I have just studied the plan that you have submitted for discharge of condition application BN/37/20/DOC regarding Land to the rear of the Lillies, Yapton Road, Barnham.

Condition 4 imposed on reserved matters approval BN/6/18/RES related to the submission of details for the pedestrian / cycle link between the application site and the adjoining Angels Nursery site.

The drawing (Drawing No. 17748-BARN-5-512 Rev. A - Footpath Link & Typical Footway Construction Detail) that you have submitted with the application only shows a footway (pedestrian) link.

SCALE	1:500 @ A2	DATE	FEB 2020
DRAWN	CLS	CHK	JGF
DRAWING NO.	17748-BARN-5-512	REV	B
TITLE	YAPTON ROAD BARNHAM		
DETAILS	Footpath Link & Typical Footway Constructon Detail

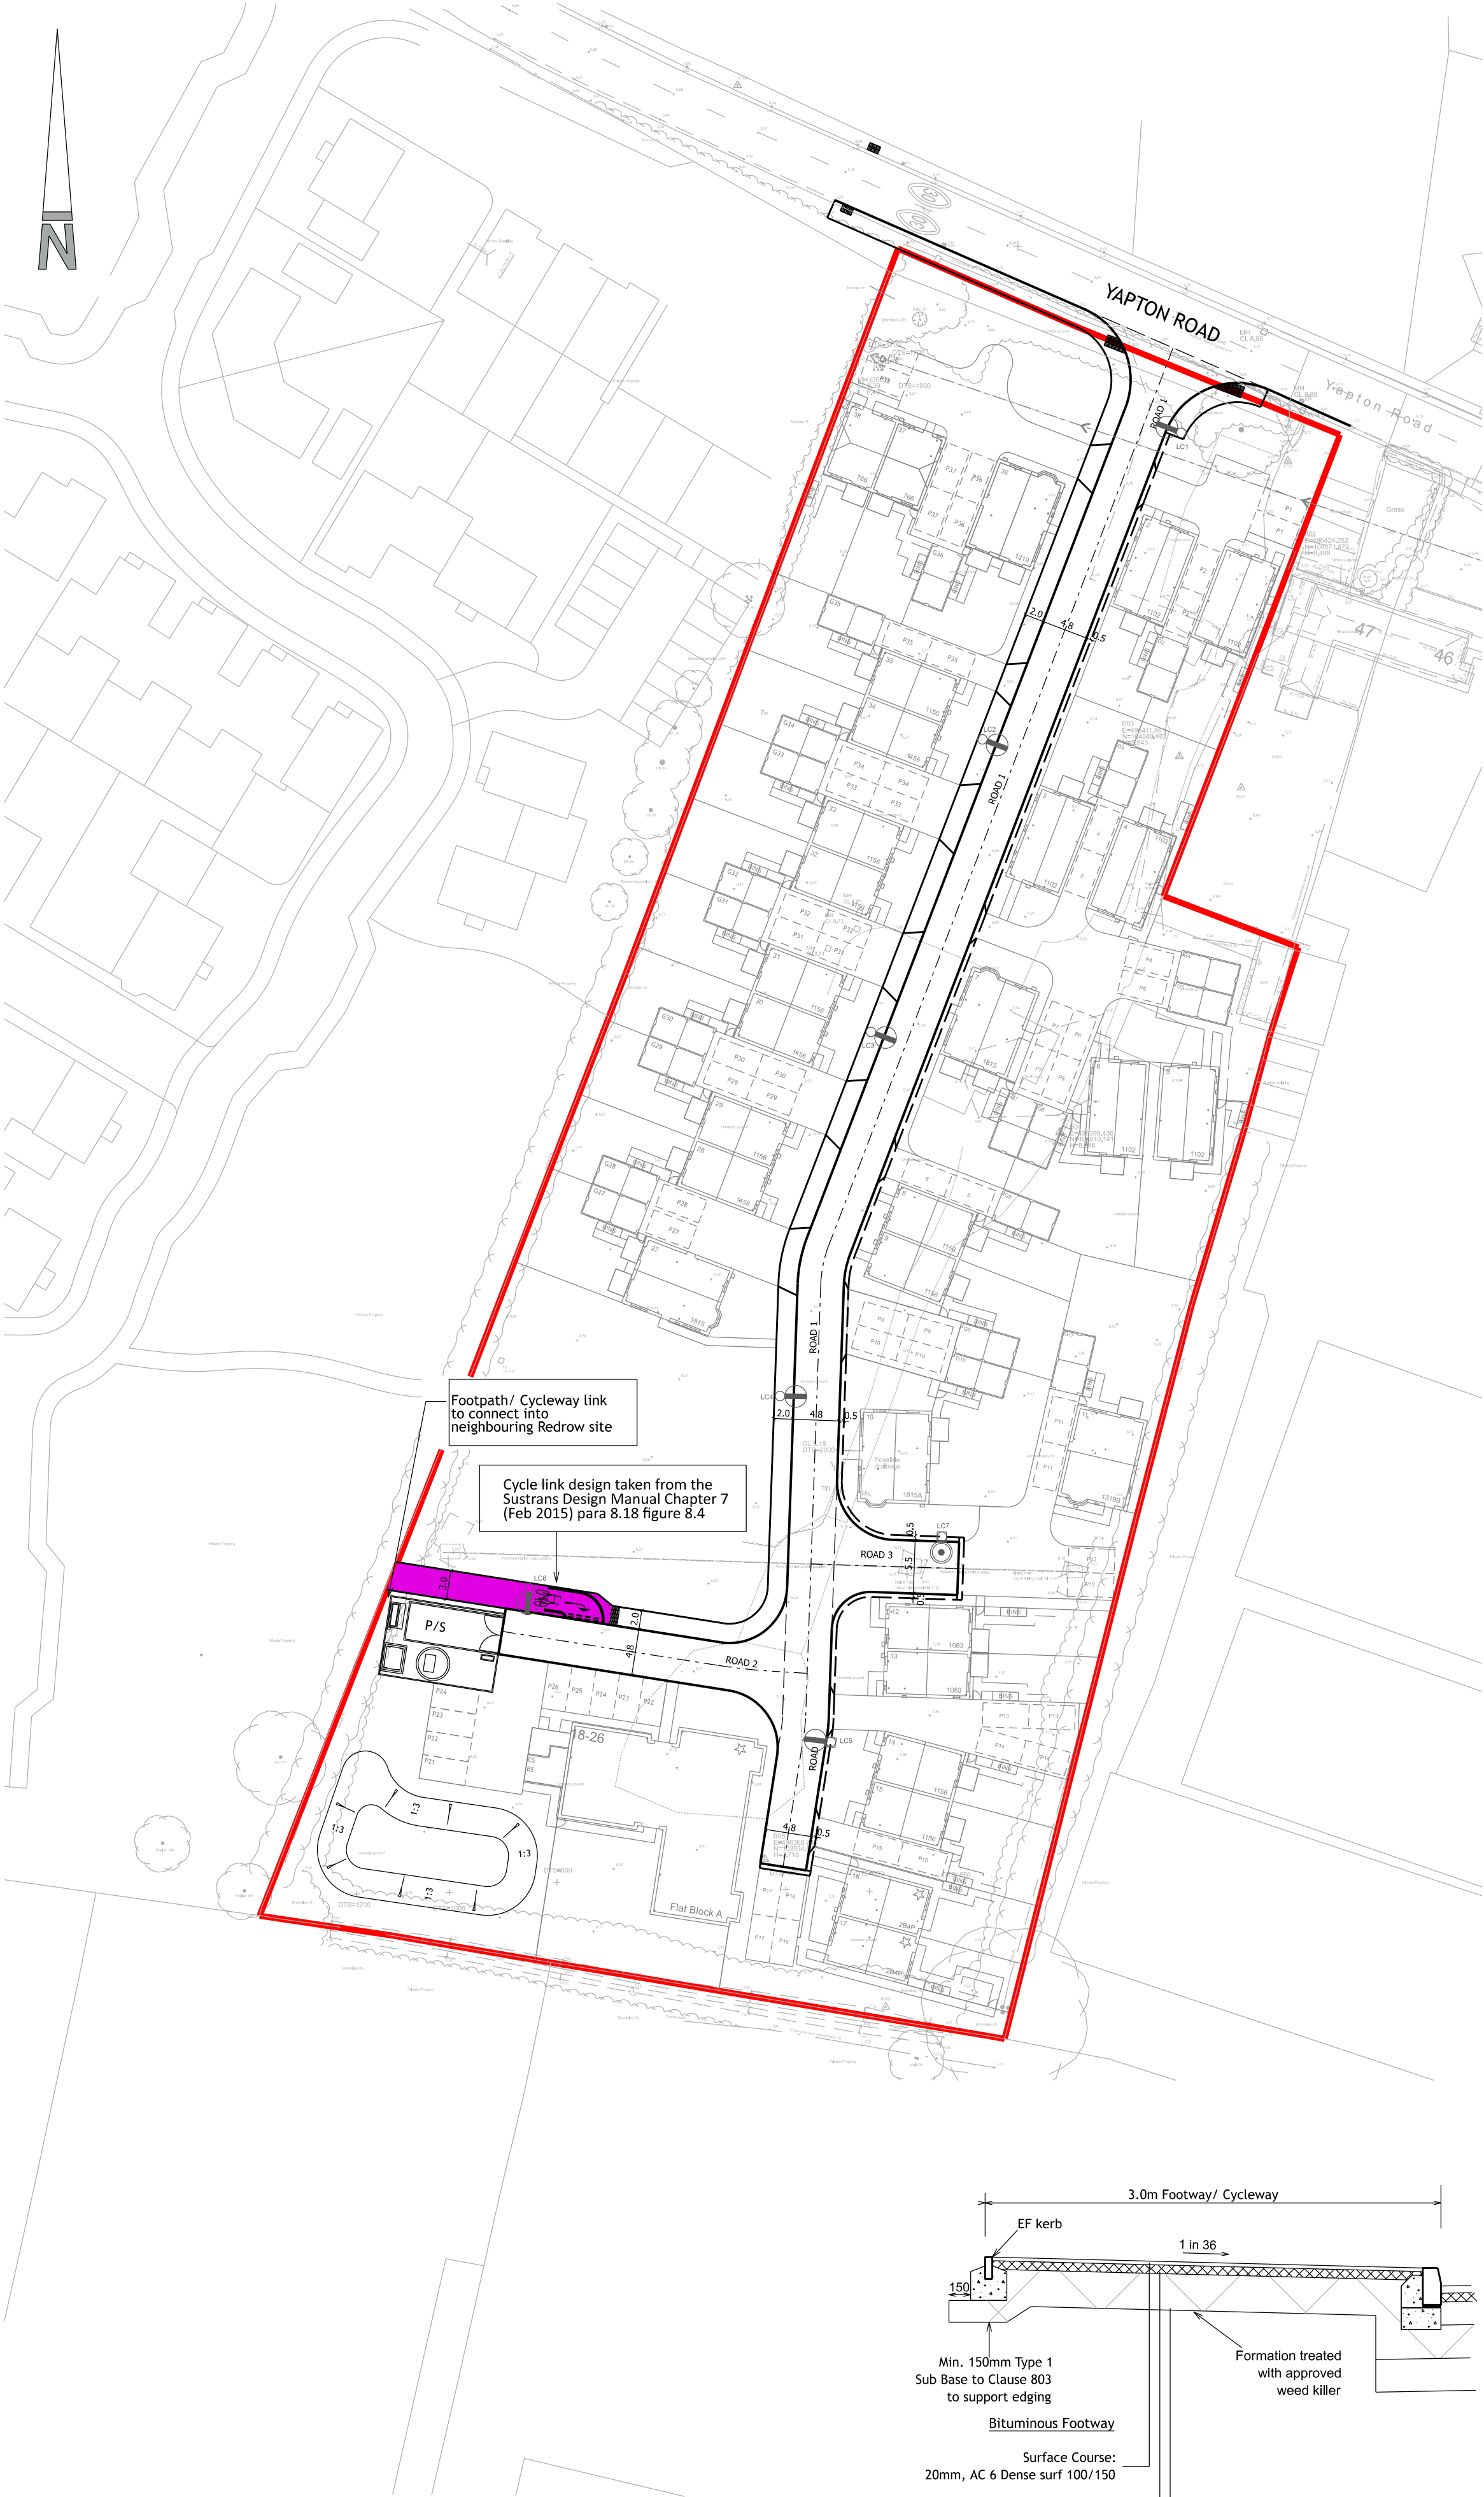
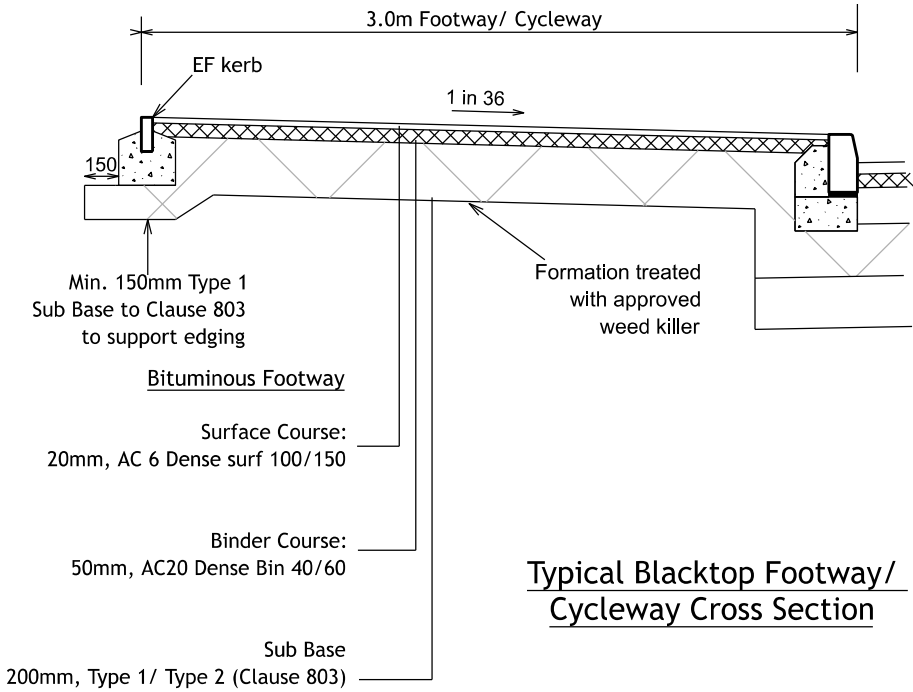
As the condition requires the provision of a pedestrian / cycle link not only a pedestrian link, I am requesting that you submit a revised drawing showing a pedestrian / cycle link of the requisite width and surfacing between the application site and the adjoining Angels Nursery site.

Please see attached the revised drawing with the pedestrian/cycle link shown.
